**RE: Chick-Fil-A @ Coors Pavilion
Coors Pavilion, Lot 6
Grading and Drainage Plan
Engineer's Stamp Date: 9/4/18
Drainage File: G11D069C**

Based on the information provided in your submittal received 9/7/18, the Grading and Drainage Plan cannot be approved until the following are addressed:

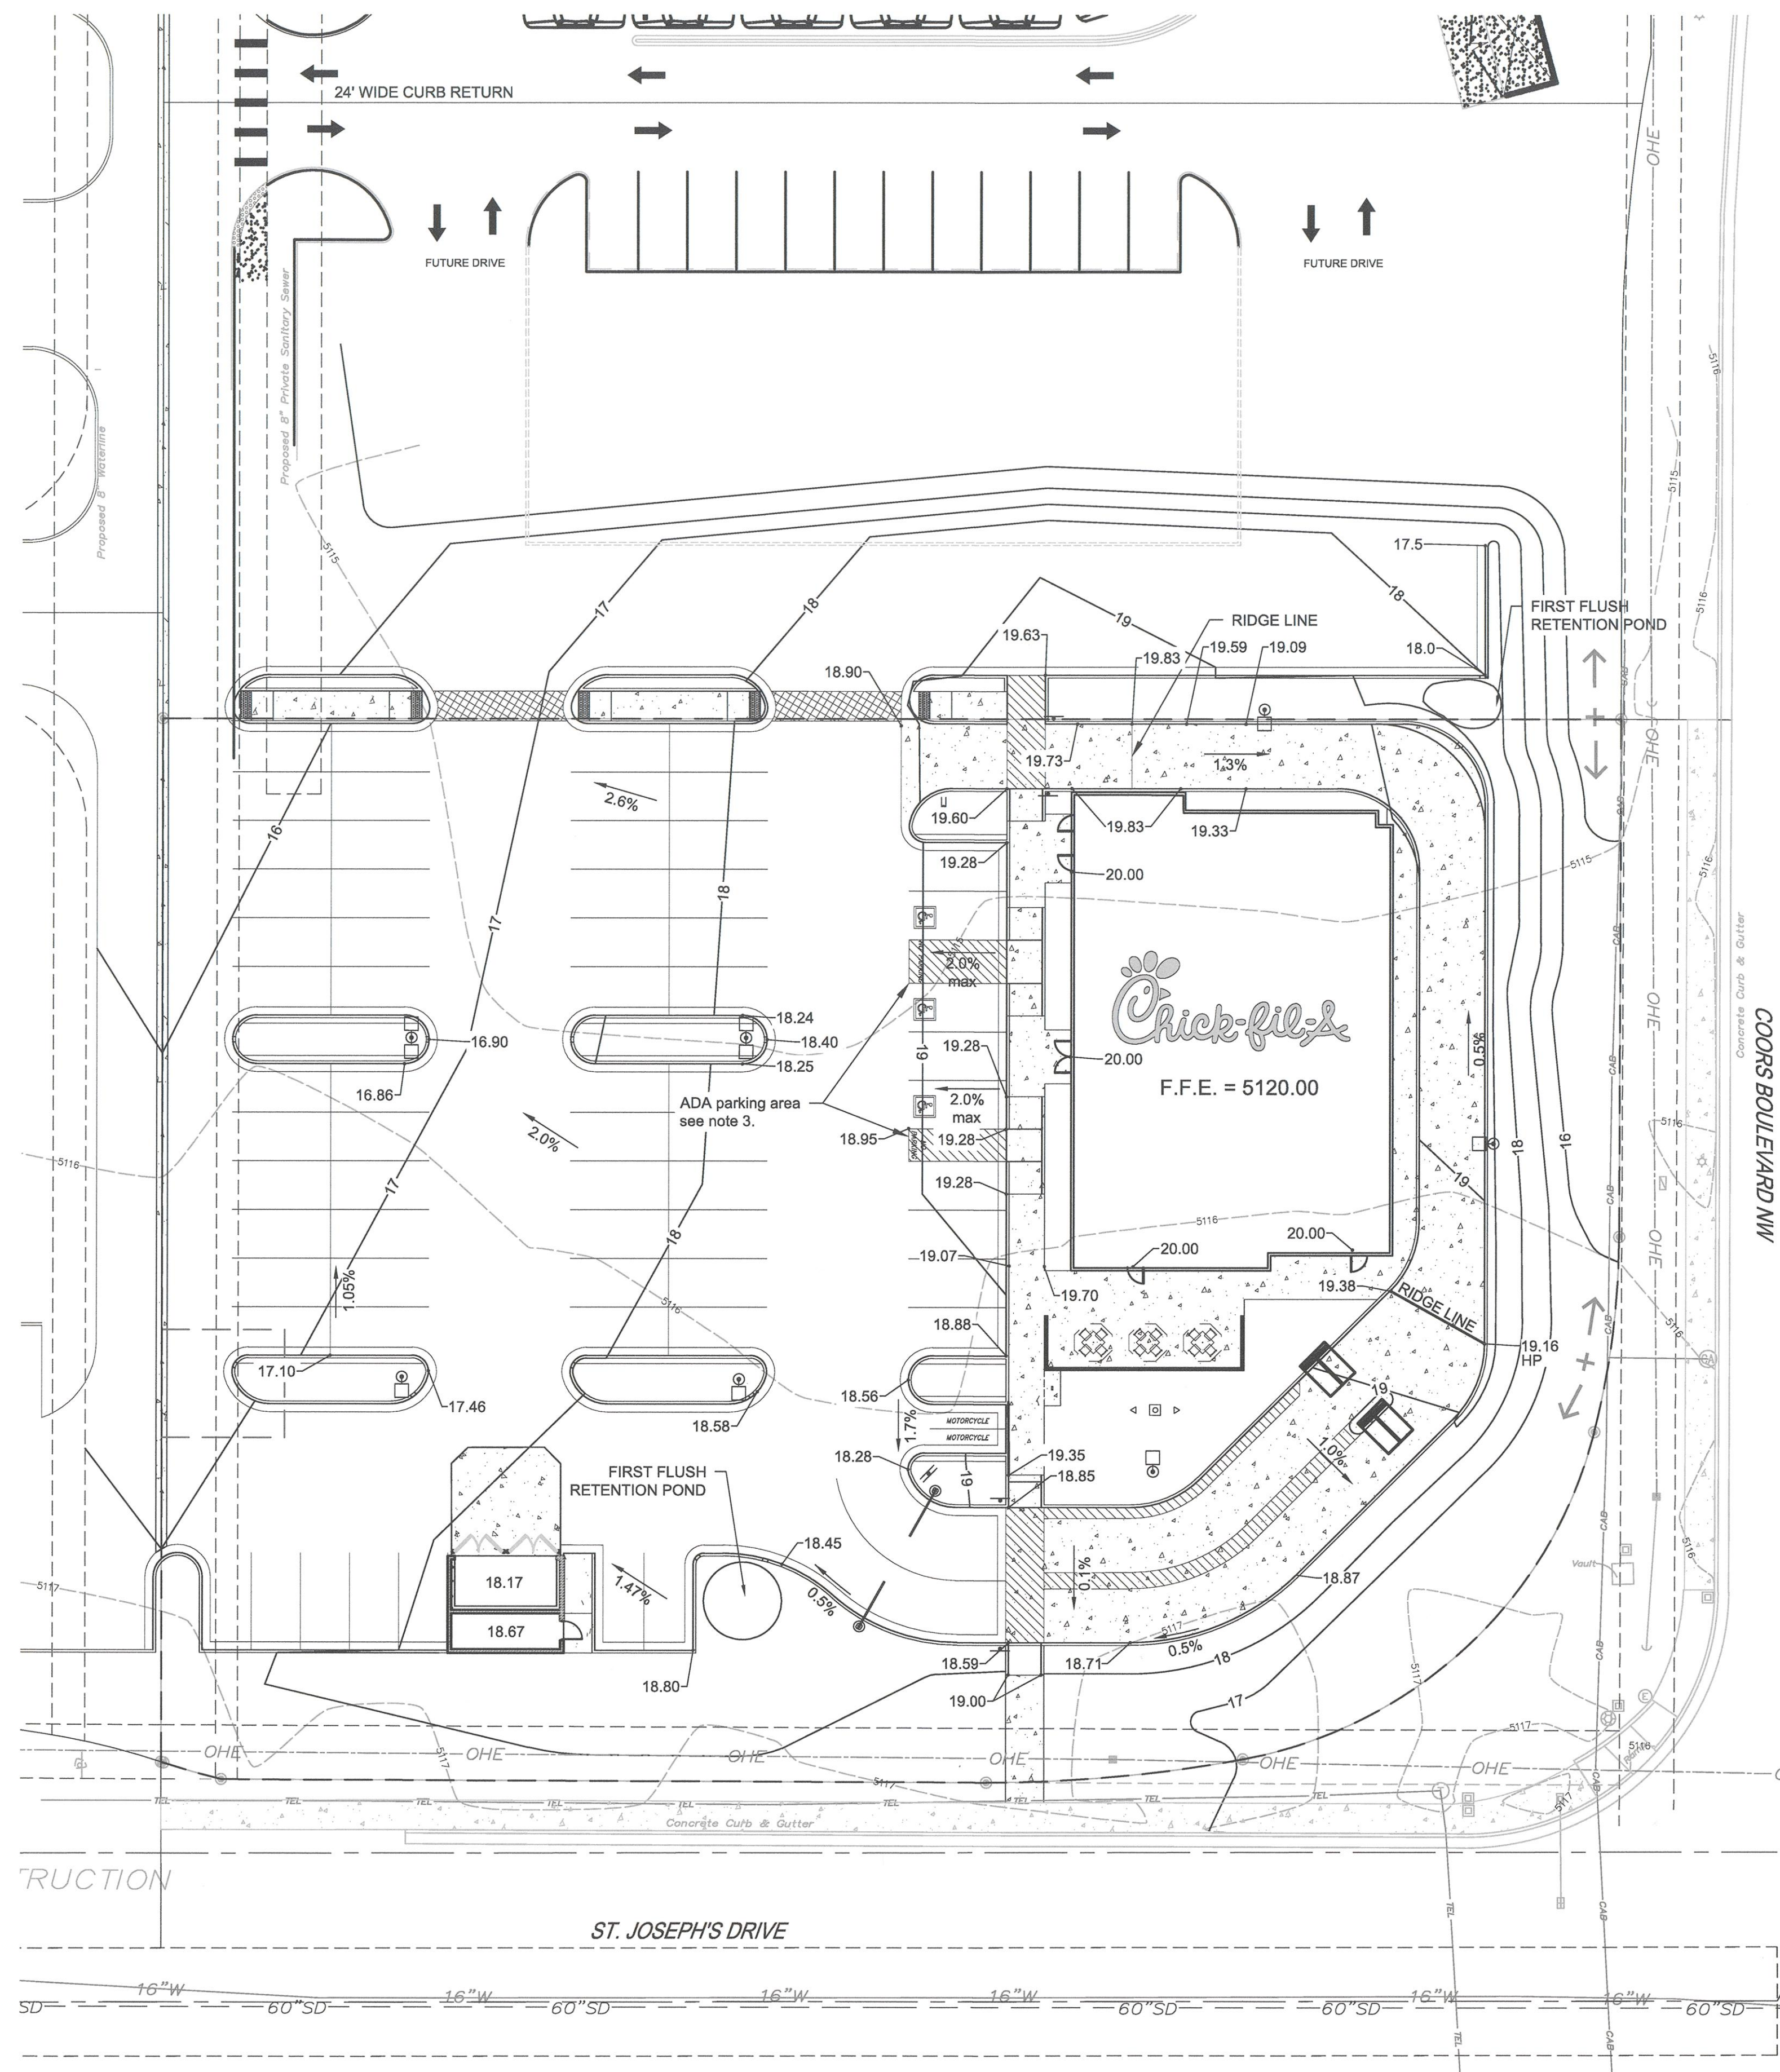
1. Provide a basin map with land treatments, areas, peak runoff, and runoff volume for each subbasin. The grading and paving on the adjacent lot (Lot 5) needs to be included as well. How will the Lot 5 grading and paving and Basin A-2 drain to the subdivision pond as defined in the subdivision master plan.

2. Provide details, dimensional data, rock graduation, and supporting calculations for the infiltration trench. This facility cannot be located in the public ROW. The City does not allow volume reduction for infiltration rate, so this trench will need to be designed as a pond minus rock volume ($e = \sim 0.30$). Ensure storage volume is provided for the contributing basins for the 100-yr, 10-day volume.

3. Why is grading shown in the ROW (City and NMDOT)? If grading is required in the NMDOT ROW, then provide the approved construction permit from NMDOT. If grading is required in the City ROW, then an Excavation Permit will be required. Hydrology recommends confining the limits of grading to the private property.
